KITTITAS COUNTY COMMUNITY DEVELOPMENT SERVICES

RE: Mitchell Short Plat (SP-17-00003) – Updated Request for Additional Information

RE: WDFW comments on SP-17-00003 Mitchell Short Plat along the Ferguson Branch of Naneum Creek

NANEUM ROAD SHORT PLAT  
 PART OF SECTION 33, T. 18 N., R. 19 E., W.M.  
 KITTITAS COUNTY, WASHINGTON

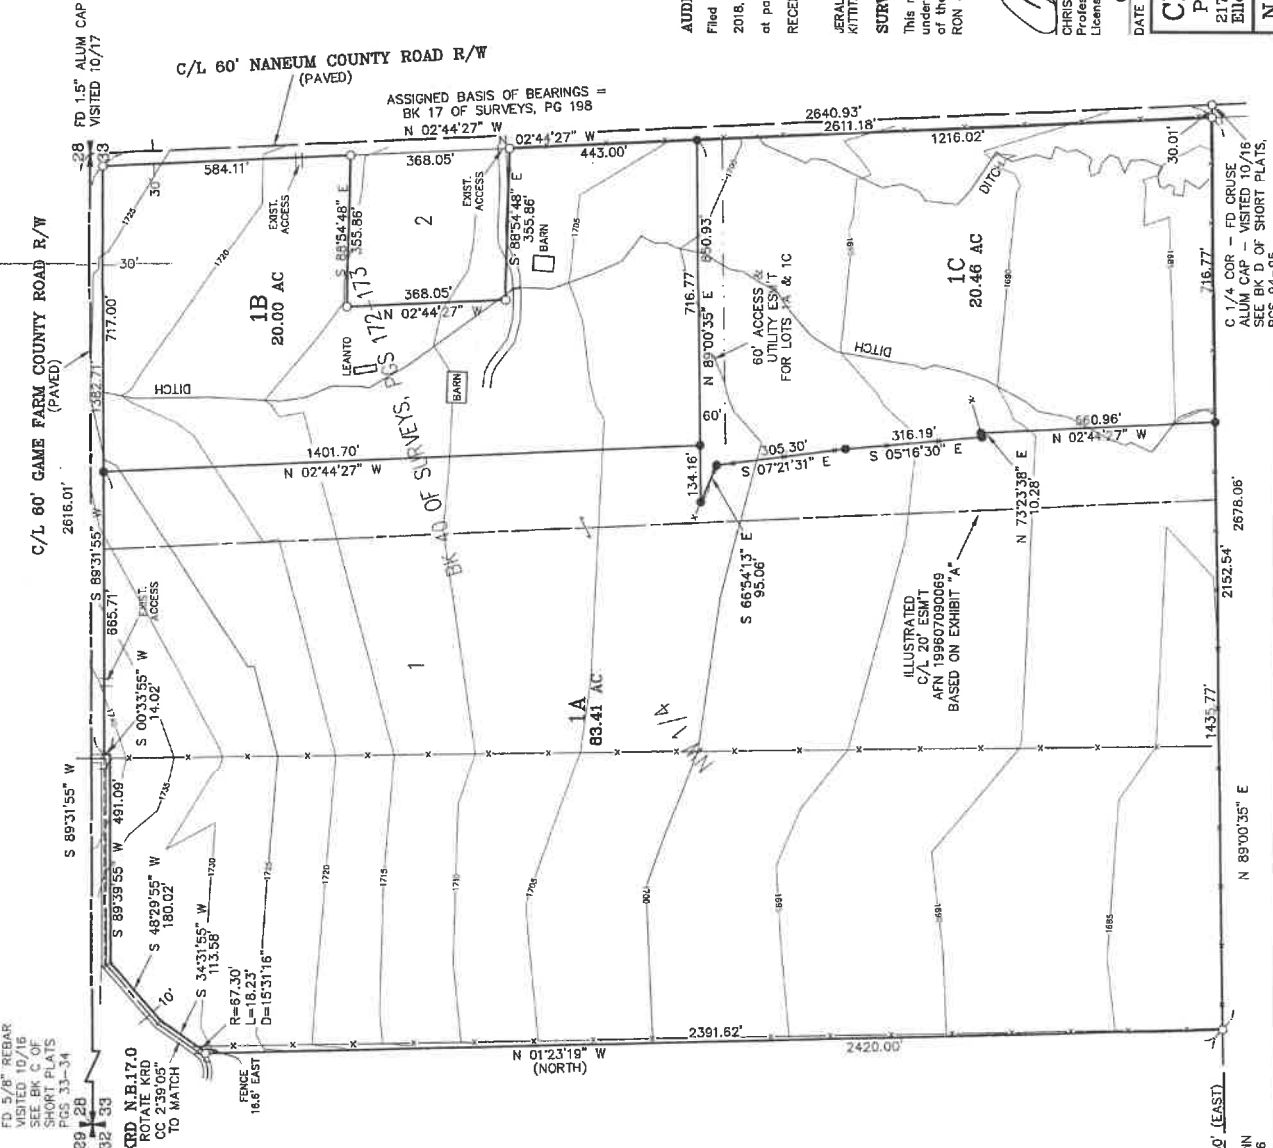
1. Site evaluations for Onsite Septic System on each proposed lot pursuant to KCC 13.04.090(1)(f) and KCC 16.12.030(7) (See attached Public Health comment letter February 22, 2018).
2. Provide one of the following:
 - a. A wetland/stream reconnaissance demonstrating there is a buildable area and access available for lot 1C
 - b. A new preliminary survey with reconfigured proposed boundary lines providing a building area and access to lot 1C
 - c. Identification of a conservation easement on the preliminary survey over lot 1CThe county does not allow creation of non-buildable lots, nor lots that would require a variance for construction to occur based on current standards (See attached Fish and Wildlife and Department of Ecology letters).
3. Identify the shoreline buffer on lot 1A (See attached Department of Ecology comment letter)

Thank you for the opportunity to comment on the proposed short plat (SP-17-00003 Mitchell) to divide the existing parcel into three lots. Naneum Creek flows southerly toward the western property boundary and the Ferguson Branch of Naneum Creek flows southerly through proposed lots 1B and 1C. The Washington Department of Fish and Wildlife's (WDFW) primary concern with this proposal is to protect the fish and wildlife habitat and other critical area functions associated with Naneum Creek and the Ferguson Branch.

events (see attachment). As currently proposed, parcels 1B and especially 1C look to have extremely limited future buildable areas if proper critical area protections are applied for 1) wetlands, 2) geological hazards (alluvial fans, channel migration zones), 3) frequently flooded areas, or 4) fish and wildlife habitat conservation areas (streams, riparian areas).

We believe lot 1C may not have a future building site that will not be at risk of flood damage and that will protect critical area functions associated with the Ferguson Branch. We recommend a reconfiguration of the proposed lots to ensure a non-buildable lot is not created with this process. Please ensure approval of this short plat will provide adequate protection to the Ferguson Branch and the critical areas associated with it into the future.
